# CITY OF ALBUQUERQUE

RE: **Starbuck's Menaul and Carlisle  
American Square  
Request for Certificate of Occupancy - Permanent  
Hydrology Final Inspection –Approved  
Grading and Drainage Plan Stamp Date: 10/24/19  
Certification Dated: 9/8/20  
Drainage File: H16D083E**

Starbucks Shell
Grading and Drainage Plan

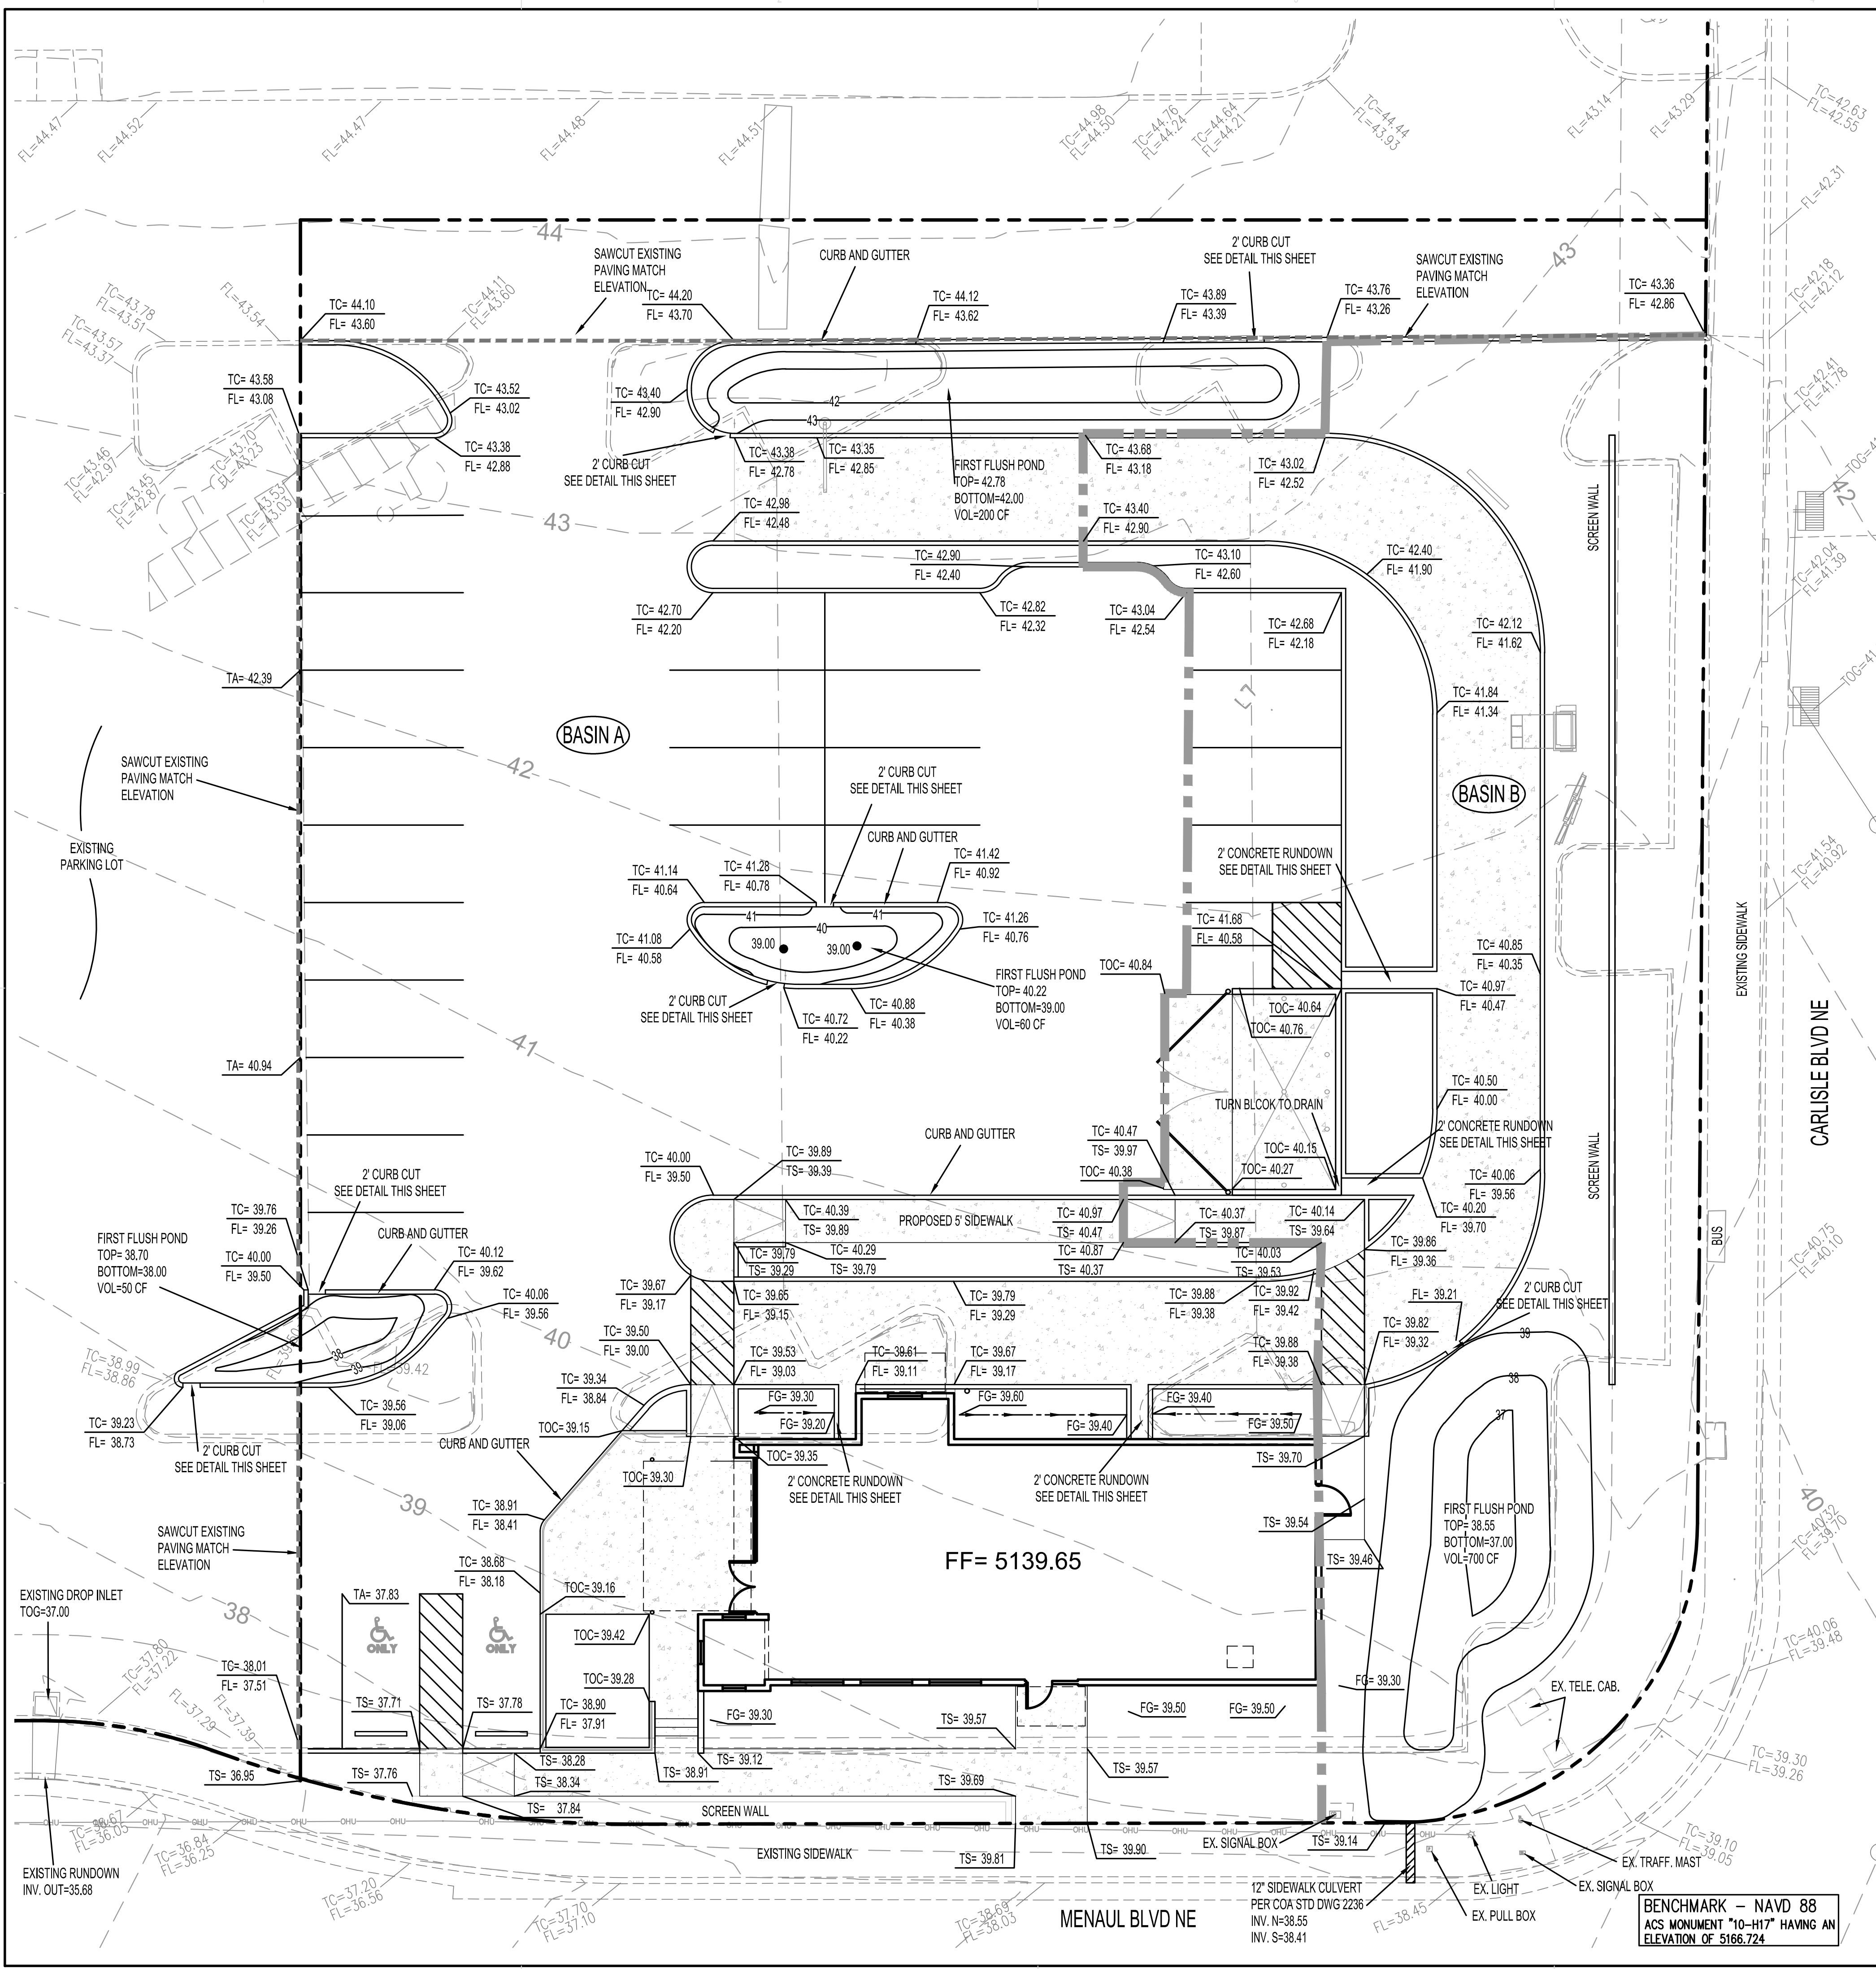
Based on the submittal received on 9/8/20 and field inspections 9/11/20, this certification is approved in support of Permanent Certificate of Occupancy by Hydrology. Please note that there is a discrepancy between the plan and what is in the field. The pond on the north side of the drive-thru entrance has a curb-cut adjacent to the entrance for storm flows to enter in to the pond, but the grades in the pond at this cut are higher than the cut and the grades outside this cut slope away from the pond. This will act more as an overflow than inlet, which is not needed for this pond. I am inclined to have this cut closed, but I do not believe it will be detrimental to the site drainage, so I will not require this to be done.
